**Gazcorp Industrial Estate Modification 1 (SSD-5248-Mod-1)**  
**Request for additional information**

I refer to Assessment for the Gazcorp Industrial Estate Modification 1 (SSD-5248-Mod-1) (the modification). The Department has reviewed the Environmental Assessment for the modification and request you to respond to issues detailed in the **Attachment 1** of this letter.

## Attachment 1 the Department's Comments on the Environmental Assessment for the Modification

Figure 3: Topography of the Project Site and Noise Receivers

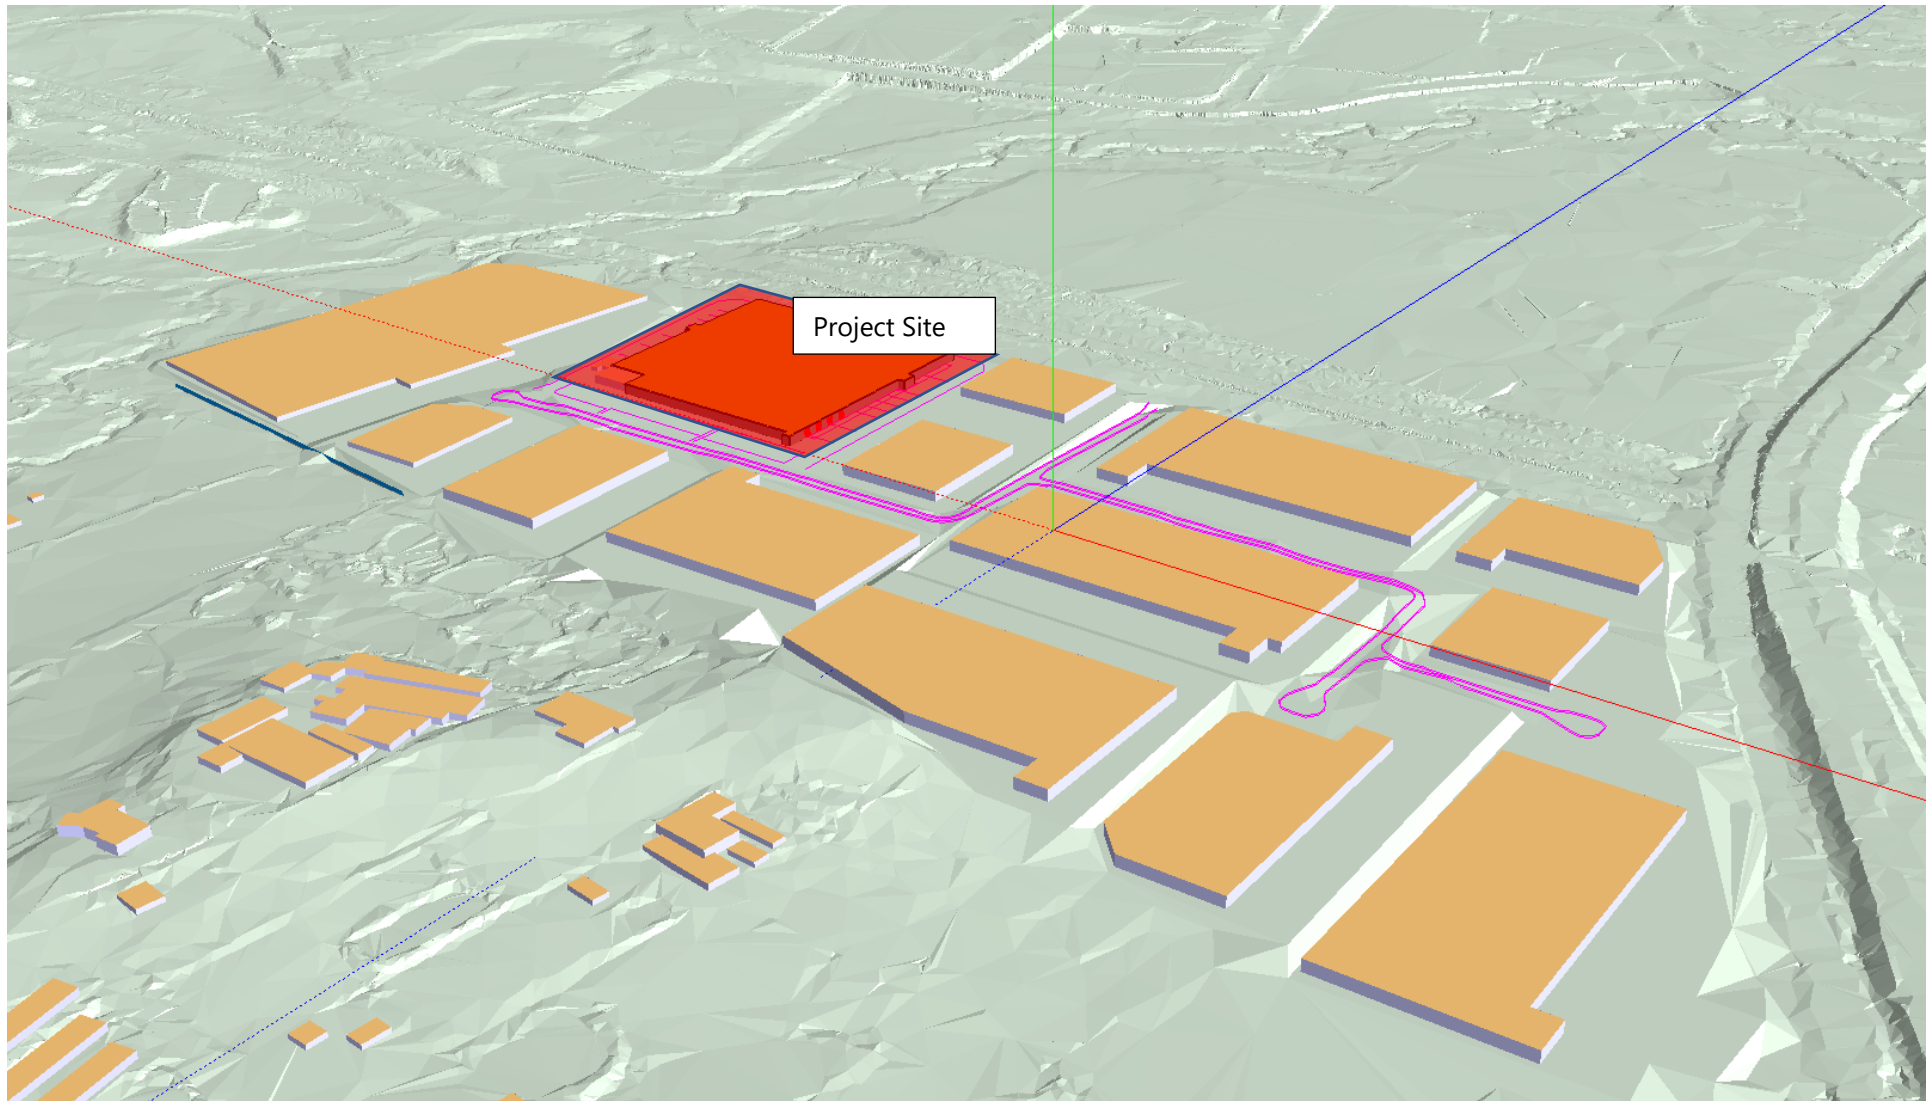
4. The NVIA defines the nearby residences as suburban. It should be rural residential despite the NVIA argues the area is dominated by traffic noise from M7 Motorway, but the background noise monitoring shows it is not. Please revised the NVIA to define the surrounding area as rural residential.

Figure 4- Sound Source Location and Data

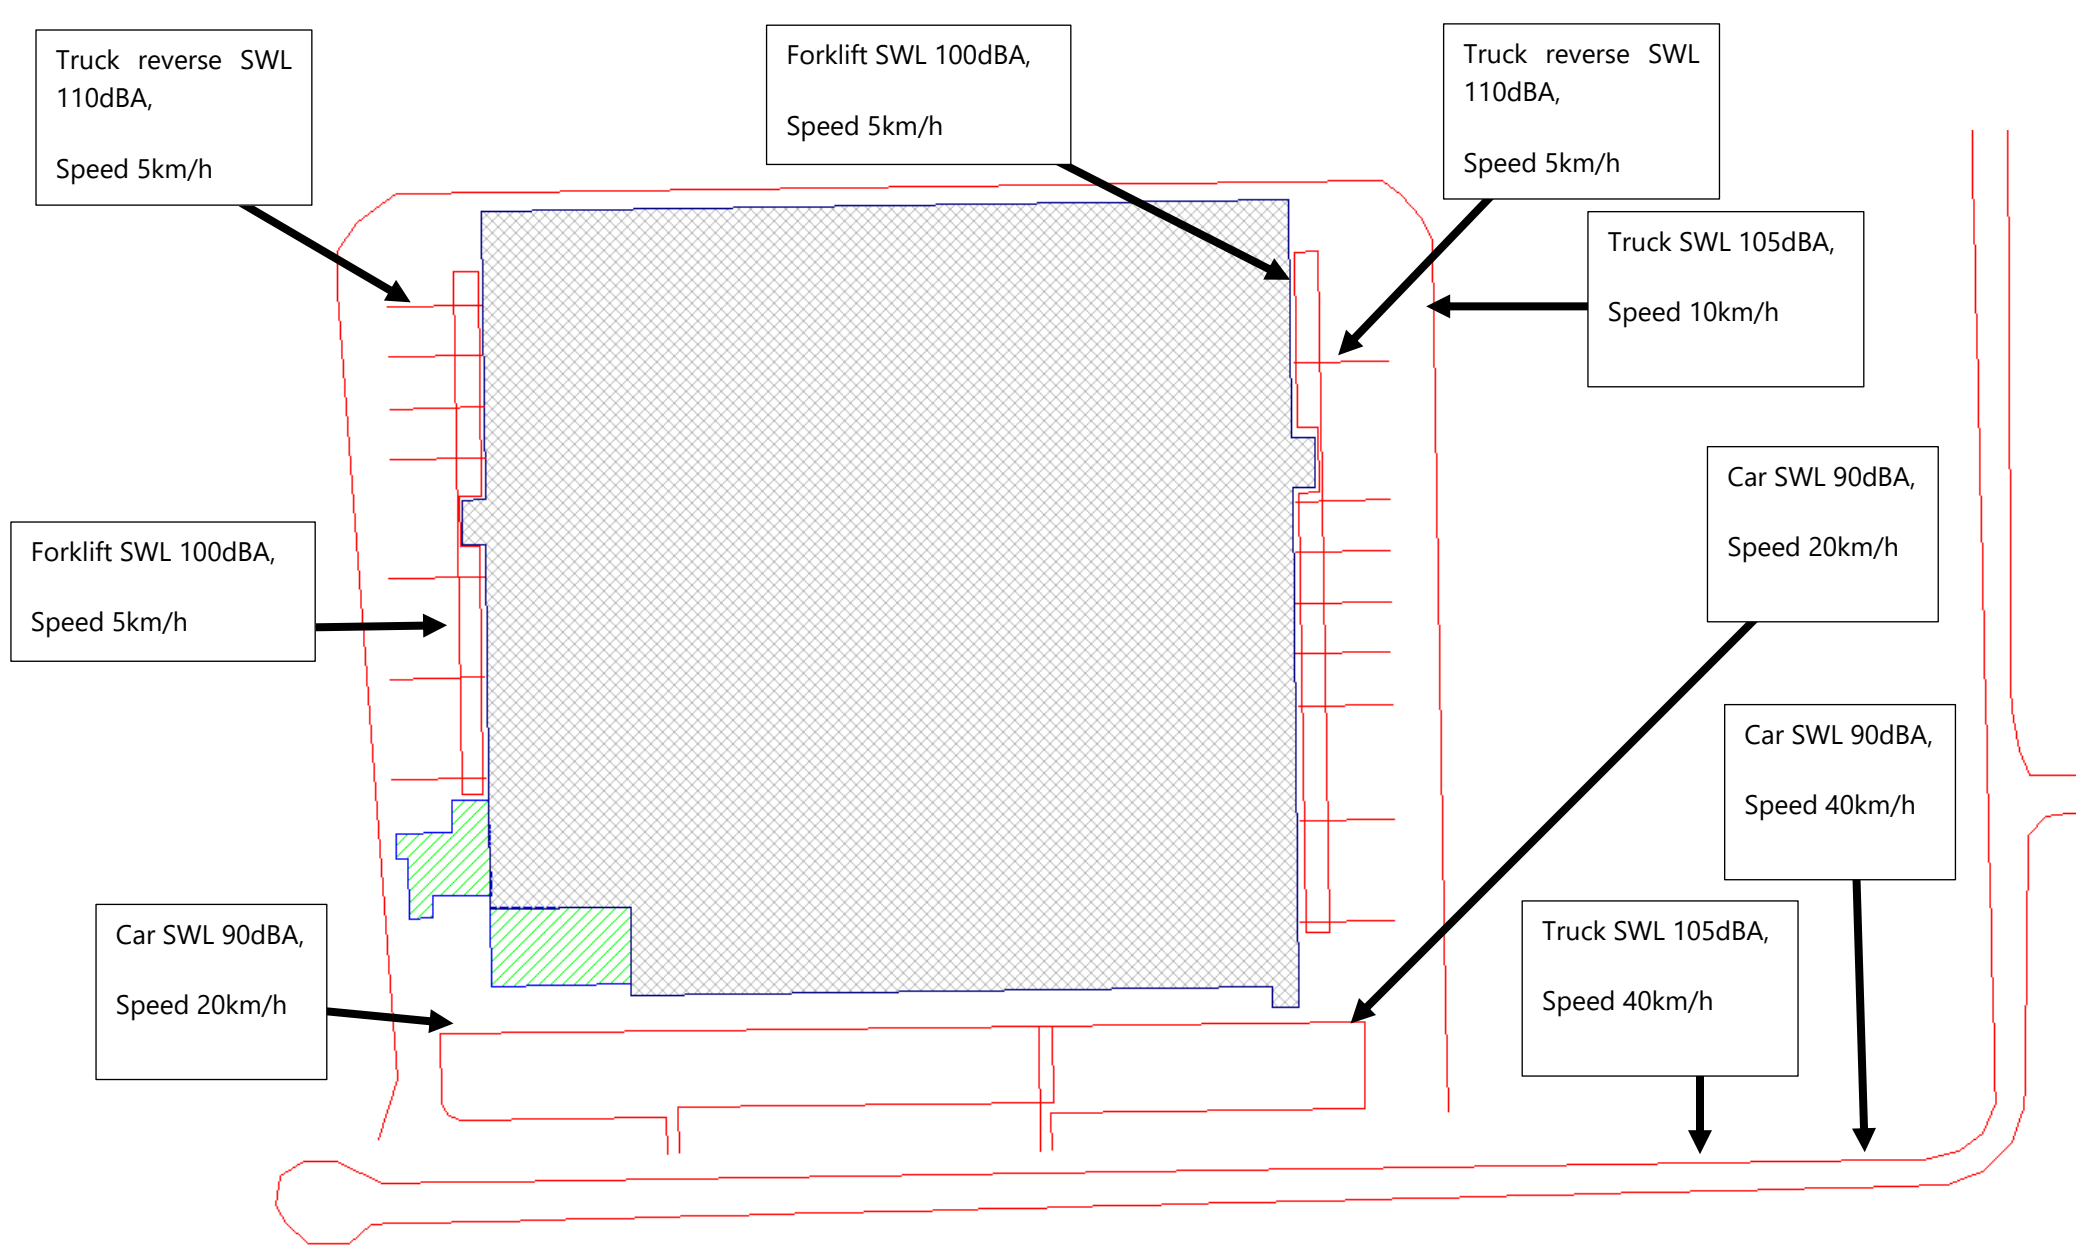
7. The NVIA must be updated to show the speed of semi-trailers when they travel along internal roads.
8. The NVIA must be revised to incorporate each distinct outdoor operation corresponding to forklift operations as well as heavy vehicles idling, passing by, accelerating, and reversing (including the contribution of energy-average noise emission associated with non-tonal reversing alarms). This would involve changes to modelled sound power levels for onsite vehicle movements and source path footprint. In addition, the representative duration of noise emission for each distinct operation also need to be amended accordingly. It should be noted that it is unlikely semi-trailers and B-doubles would be able to consistently manoeuvre at certain speed within the site. The operational noise modelling must consider 'worst-case' emission scenarios.  
The Department requires all operational modelling assumptions be clearly identified and justified in the amended NVIA, including an updated source emission inventory that delineate steady and non-steady noise generating activities and a visual illustration that maps the location of modelled sources. The NVIA shall adhere to the reporting requirements for steady and non-steady sounds specified in the Australian Standard AS 1055:2018 Acoustics – Description and Measurement of Environmental Noise.

9. The NVIA only consider noise emissions from forklifts' reversing alarm and doesn't consider noise associated with forklifts movements in loading dock areas as well as loading and unloading activities. The NVIA must be updated to include these noise emissions.

10. It is unclear which type of sound power level in Table 8 of the NVIA represents (i.e. L<sub>90</sub>, L<sub>10</sub>, L<sub>Amax</sub> or L<sub>eq</sub>). Please clarify.

11. Please clarify which noise generating sources detailed in Table 8 of the NVIA are steady and which are non-steady.
